Appeal Decision

Decision date: 13 June 2025

Appeal Ref: APP/R5510/W/25/3360251

6 Newlyn Close, UXBRIDGE, UB8 3PA

PROPOSED SITE / BLOCK PLAN

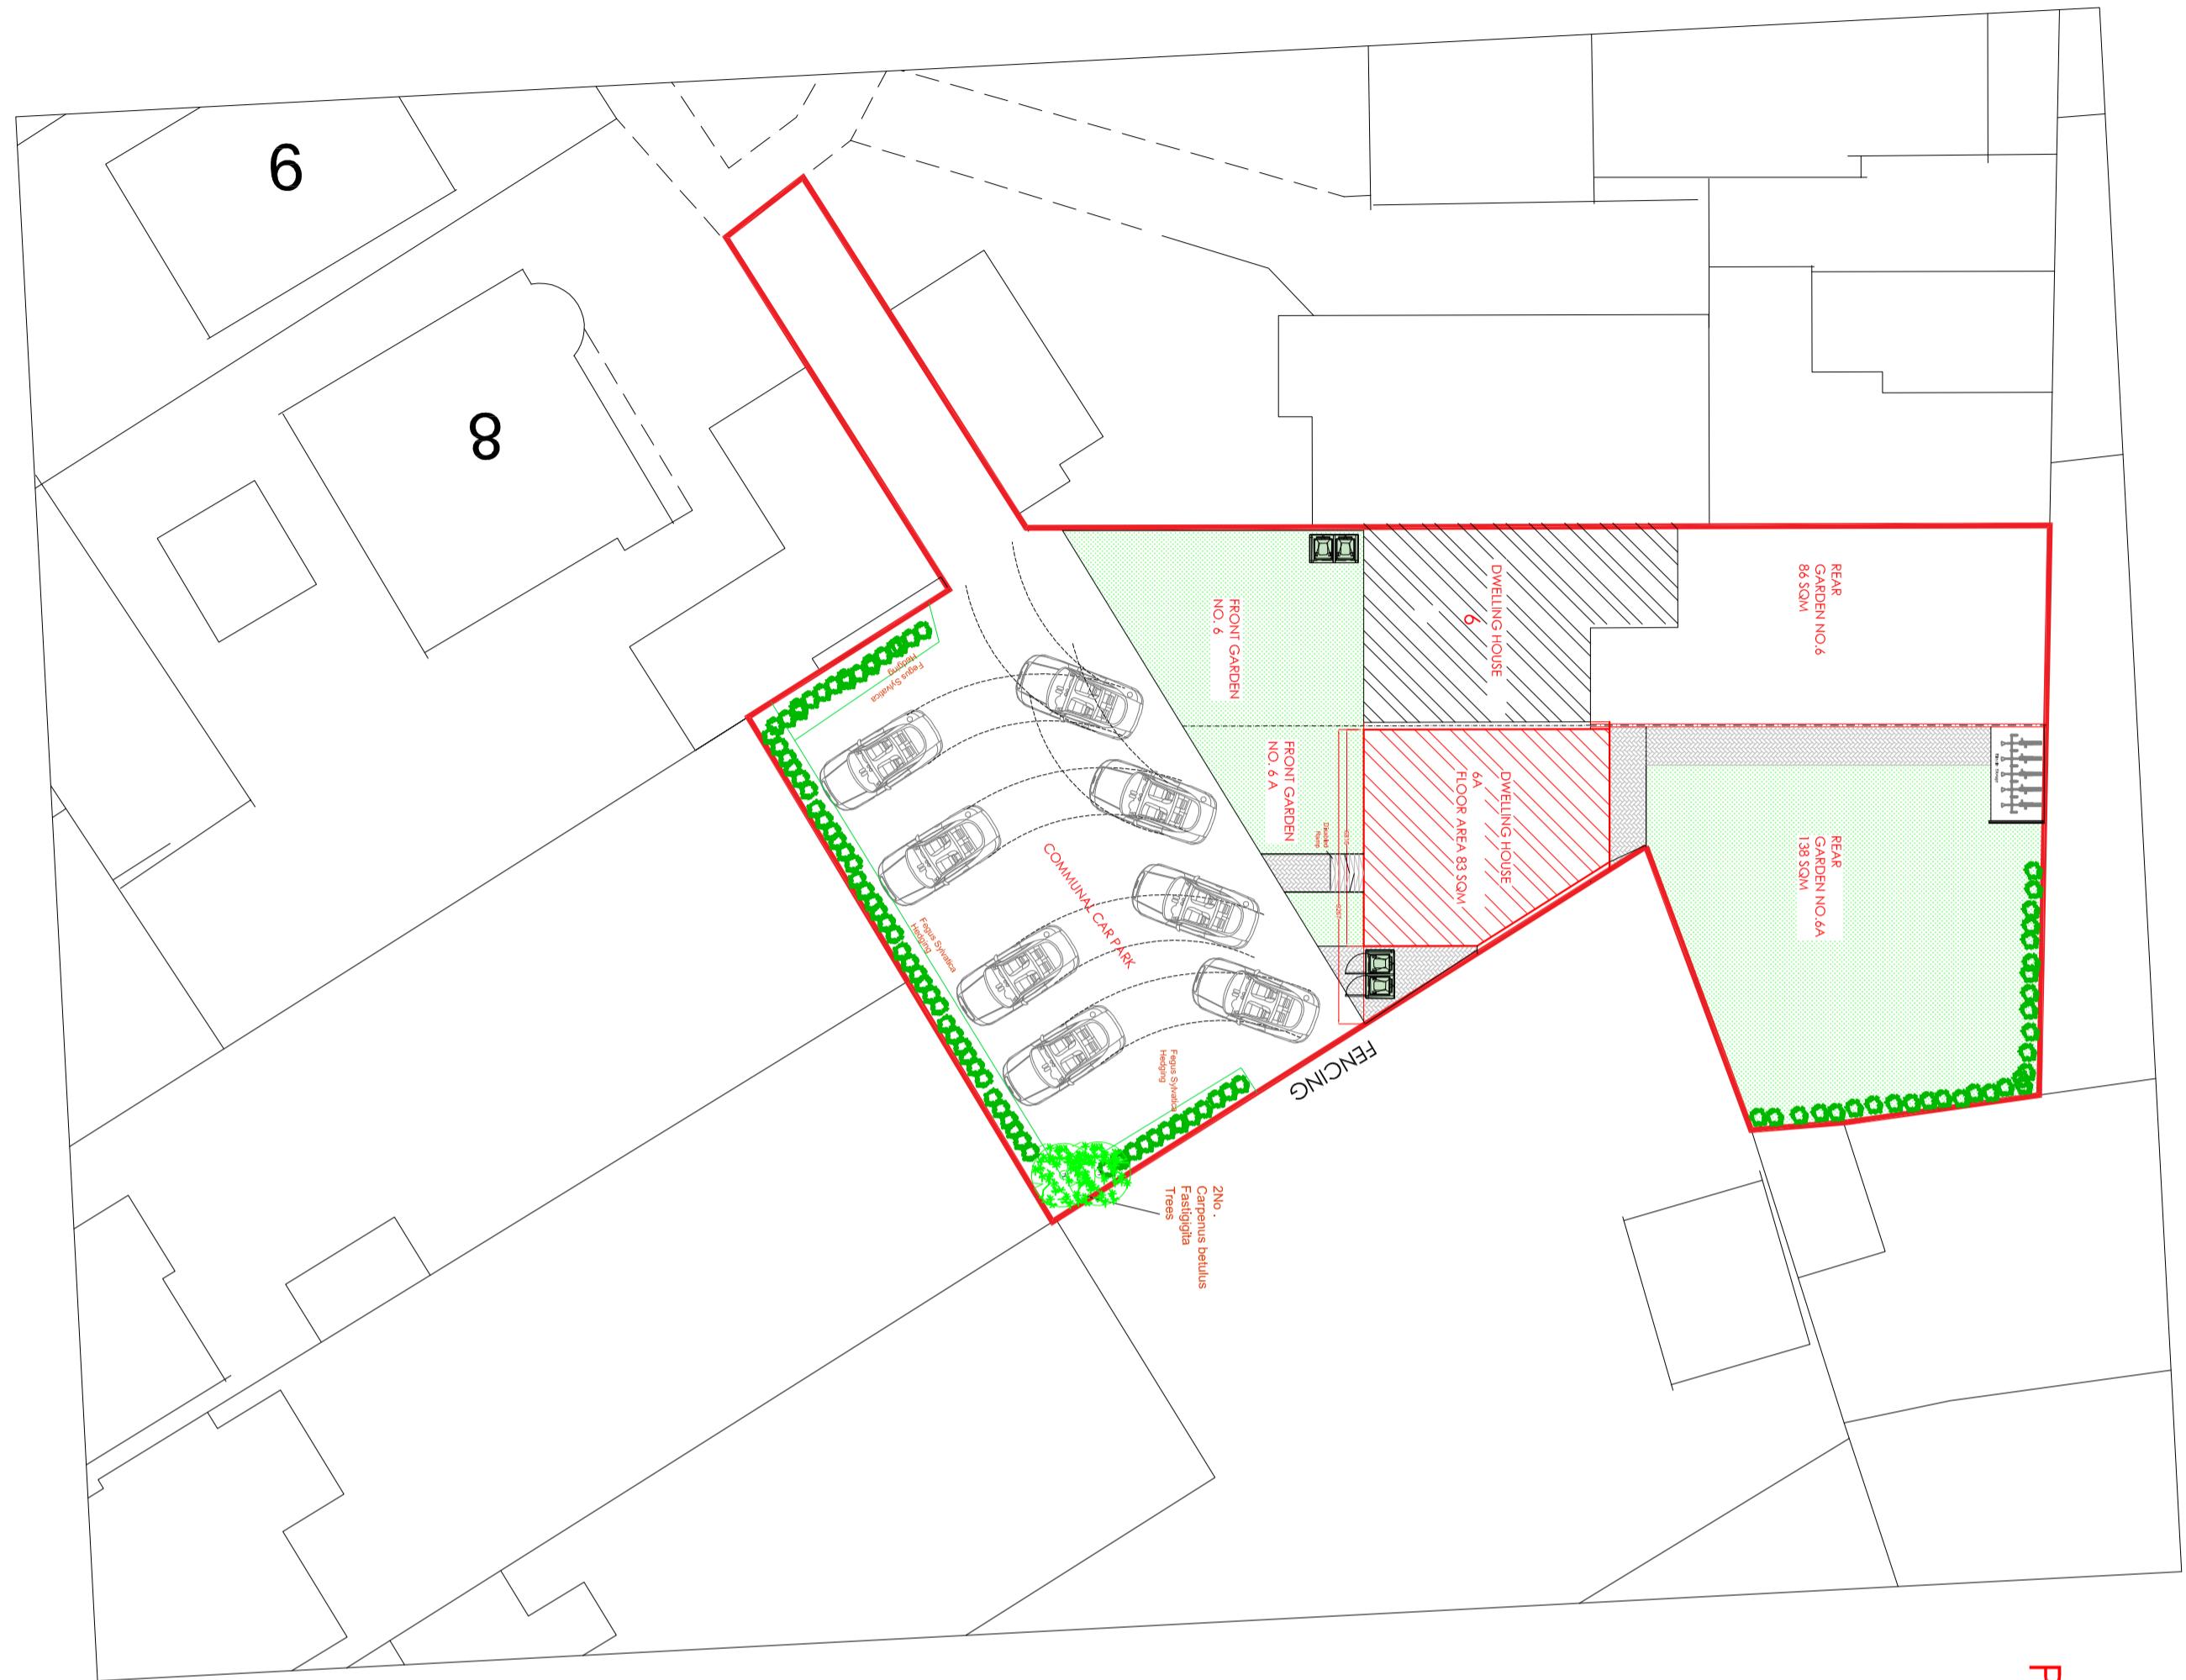
7. I observed that there were numerous mature trees both on the site and overhanging it. The site plan does not illustrate these, only referencing one conifer that would need to be removed. Having seen the site, I consider it highly likely that more trees would need to be removed or reduced in size to enable the development.

14. However, the house would be tightly constrained by the boundary of the site, which would necessitate an angled building and cause the plot to appear cramped. This sense of overdevelopment would be exacerbated by the removal of outbuildings to build a parking area for 4 cars. I conclude that the site would appear overdeveloped when compared to the prevailing grain and character of the area, and that this would be to a harmful extent.

15. The site also contributes to a line of trees that create an attractive backdrop to Newlyn Close. As discussed above, in the absence of evidence to the contrary it seems likely that some of these trees would be lost, which would lead to harm to the character and appearance of the area. The plans show the addition of a single tree in the corner of the car park and narrow 'plantation' around the edge of the site. It has therefore not been clearly demonstrated that the visual harm from loss of trees could be mitigated through landscaping.

18. There would be a lack of turning space in the parking area. The swept path analysis only demonstrates that there is sufficient room for 4 cars to manoeuvre into an empty space. Based on the plan provided, if all spaces were filled it would not appear possible for additional vehicles, including service and delivery vehicles to turn around. This would result in them having to reverse down the lane to leave the site and into the close. There is also a small risk that cars would meet each other in the lane and one would have to reverse. Increasing the chance of reversing down a lane with sub-optimal visibility into a residential close would increase the risk to highway safety, although I consider this increase to be small, given the low number of users and length of lane.

Proposed Plans

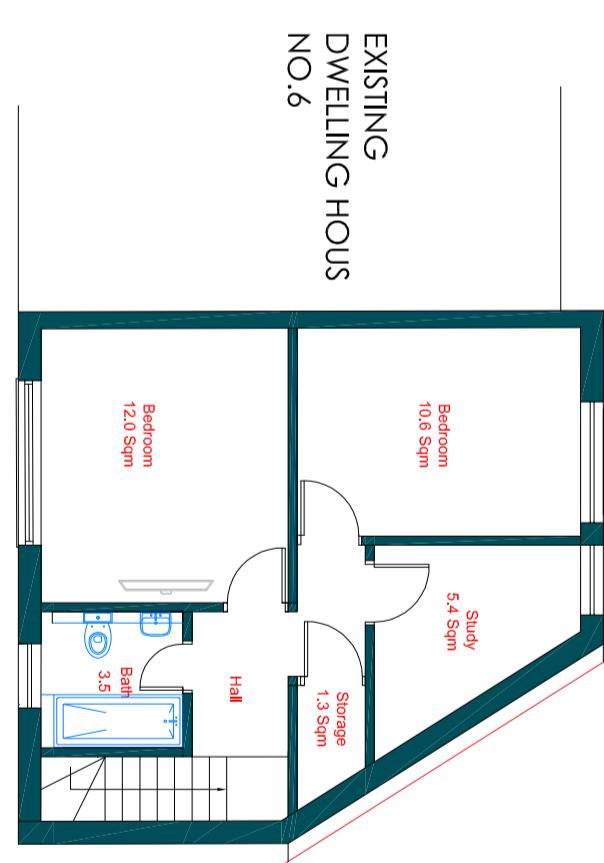
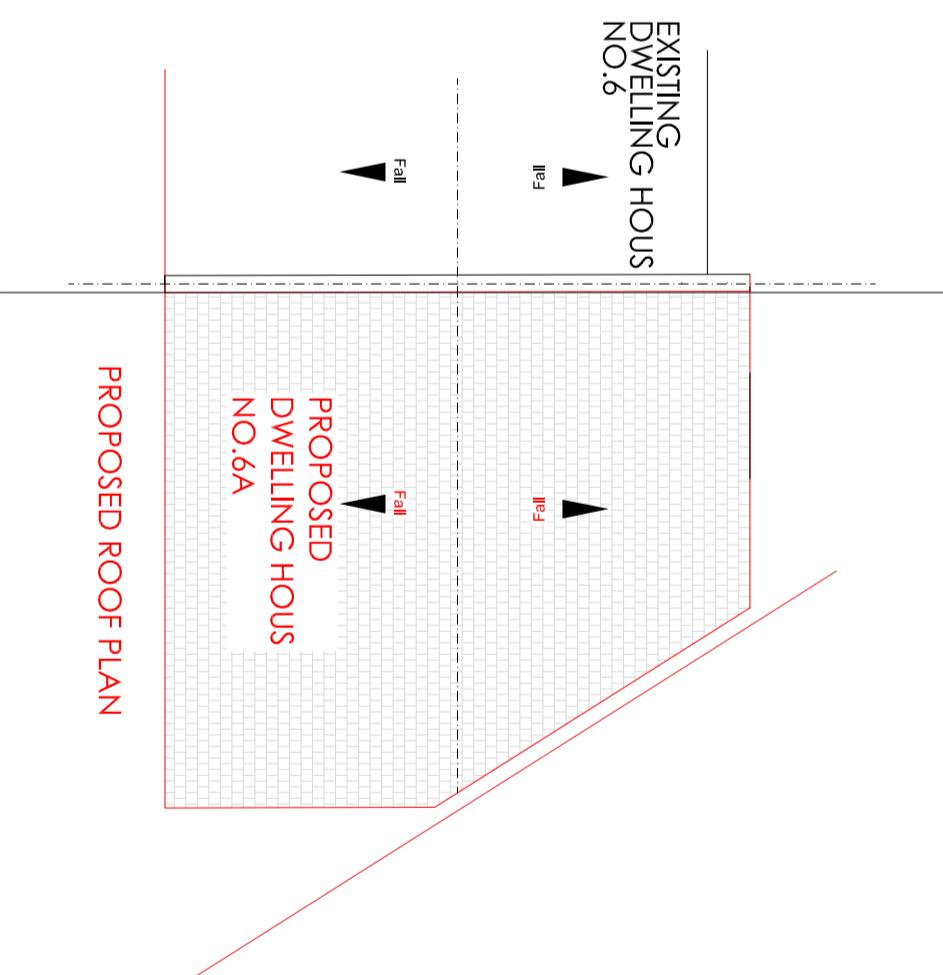
21. A cycle store is proposed in the back garden and bicycles would have to be carried through the house. This would be inconvenient and therefore contrary to Policy DMT5 of the Local Plan. Policy T5 of the London Plan also requires that bicycles must be located in an accessible location and as near as possible to the building entrance, which this proposal does not fulfil.
22. The proposal would increase the risk to highway safety and does not meet the requirements in relation to sustainable transport. It is therefore in conflict with Policies T2, T4 and T6 of the London Plan, and Policies DMT 1, DMT 2, DMT 5 and DMT 6 of the Local Plan, which maximise safe and convenient access, and promote walking and cycling.
